## PLAN REVIEW SHEET

<b>Date:</b>	05/16/2008	<b>Staff Contact:</b>	David McDonald
<b>Petitioner:</b>	Moody Lake Office Park Development Limited Partnership	<b>Telephone:</b>	704-336-6900
<b>Petition:</b>	2008-090	<b>Fax:</b>	704-432-1277
<b>Location:</b>	Approx. 7.06 acres on the SE corner W. Arrowood Rd & Sandy Porter Rd.	<b>Email:</b>	<a href="mailto:dmcDonald@ci.charlotte.nc.us">dmcDonald@ci.charlotte.nc.us</a>
<b>Existing Zoning:</b>	B-1(CD) and O-2(CD)	<b>Attachments:</b>	WP_w5x10BoxShelter_wPS_60.03A
<b>Requested Zoning:</b>	B-2(CD) and O-2(CD) To provide owner with option of locating a hotel/motel use on that portion designated as parcel A and to revise the height limitation.

#### *FIRST SUBMITTAL*

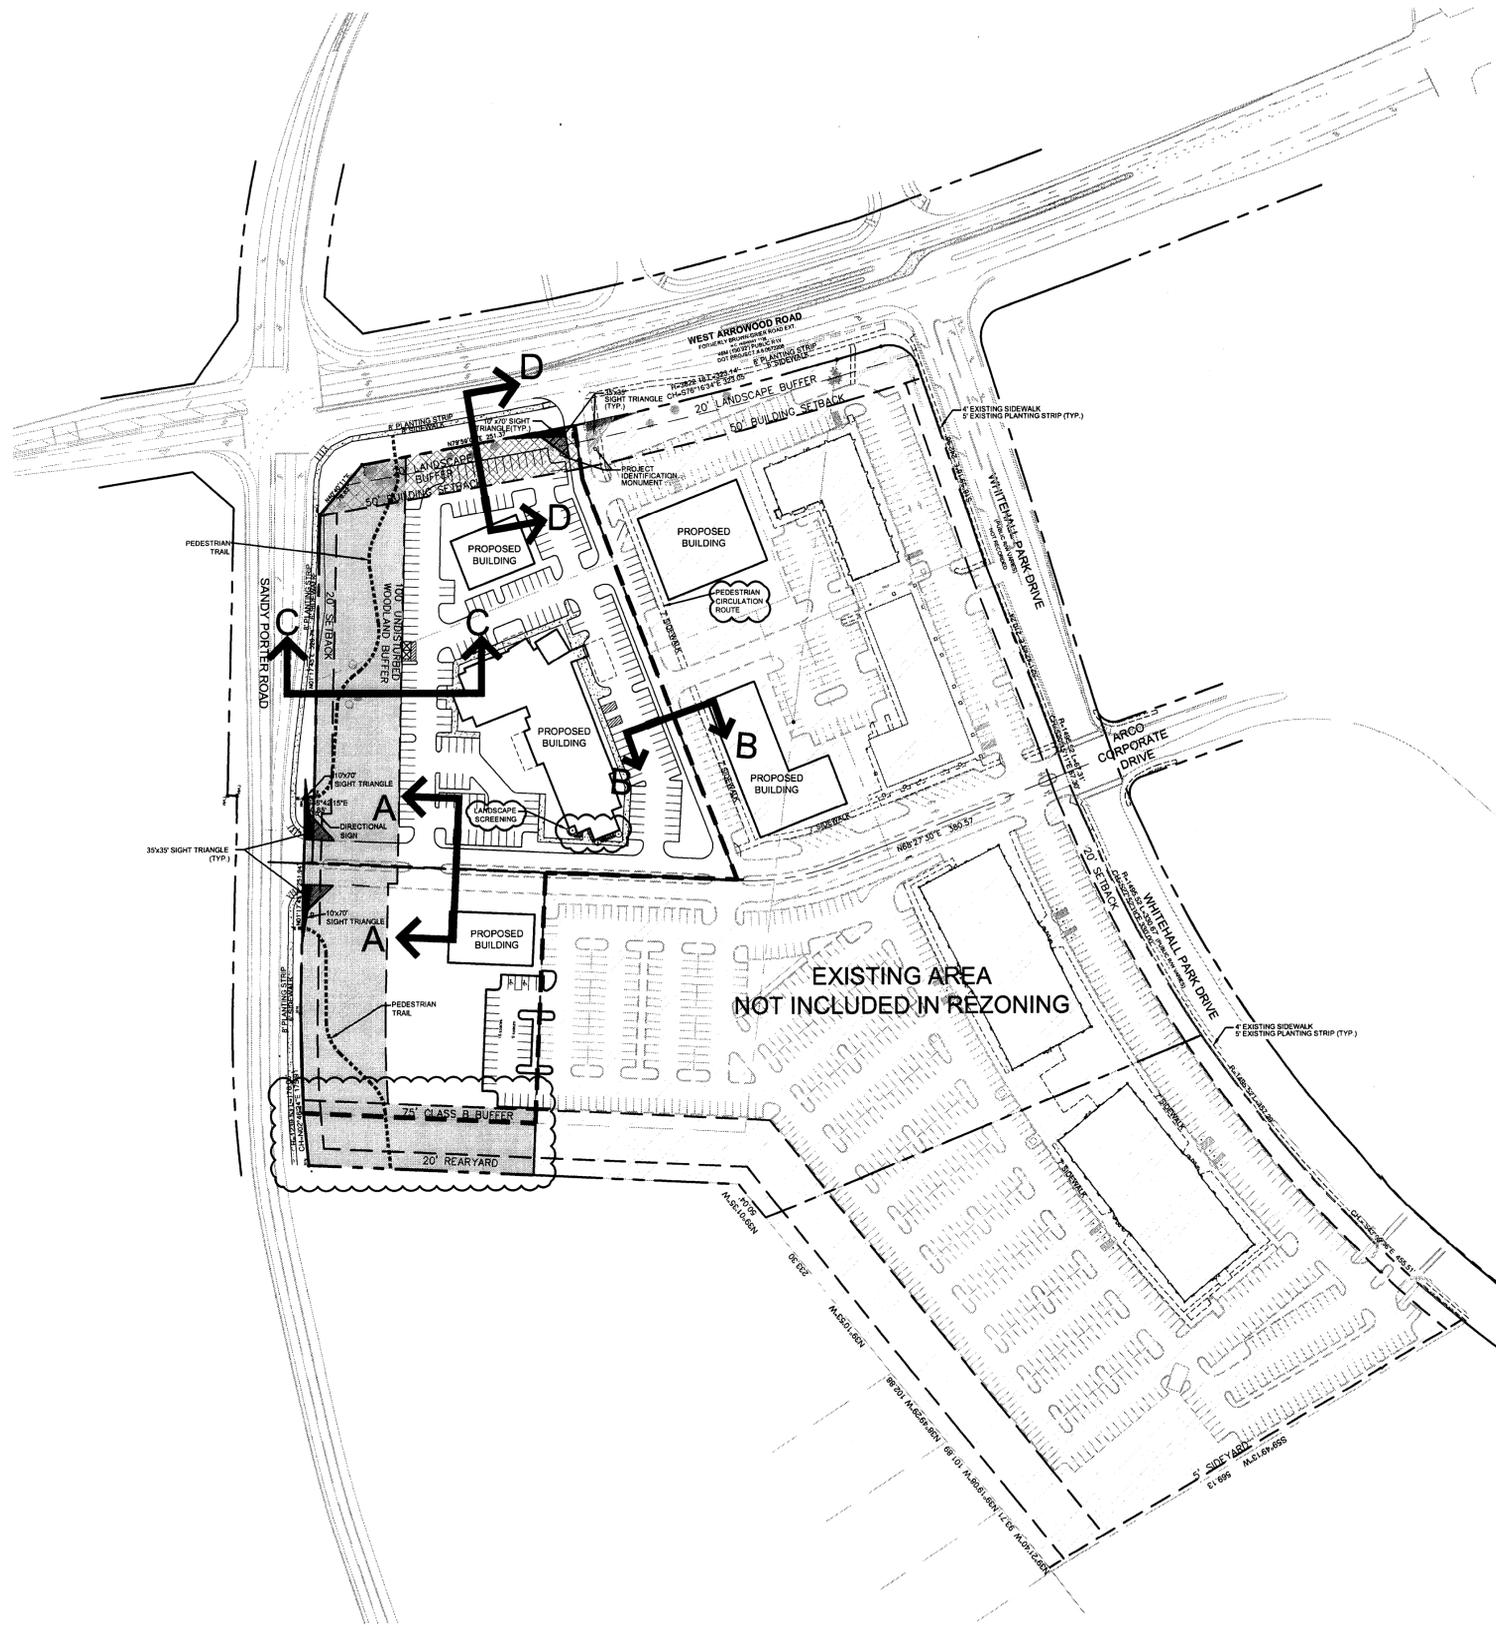
- 1) The petitioner's site is currently served by CATS Route 55: Westinghouse.
- 2) CATS requests a shelter pad to be constructed on Arrowood Road. The shelter pad should be located approximately 60' from the intersection of Arrowood Road and Sandy Porter Road, constructed to CATS Development Standards 60.03 A (see attached).

Please designate such in the site plan and/or accompanying notes. Please contact Leonard Ganther (CATS Operations) @ 704.432.1283 prior to demolition or construction, to coordinate the final location of the shelter pad.
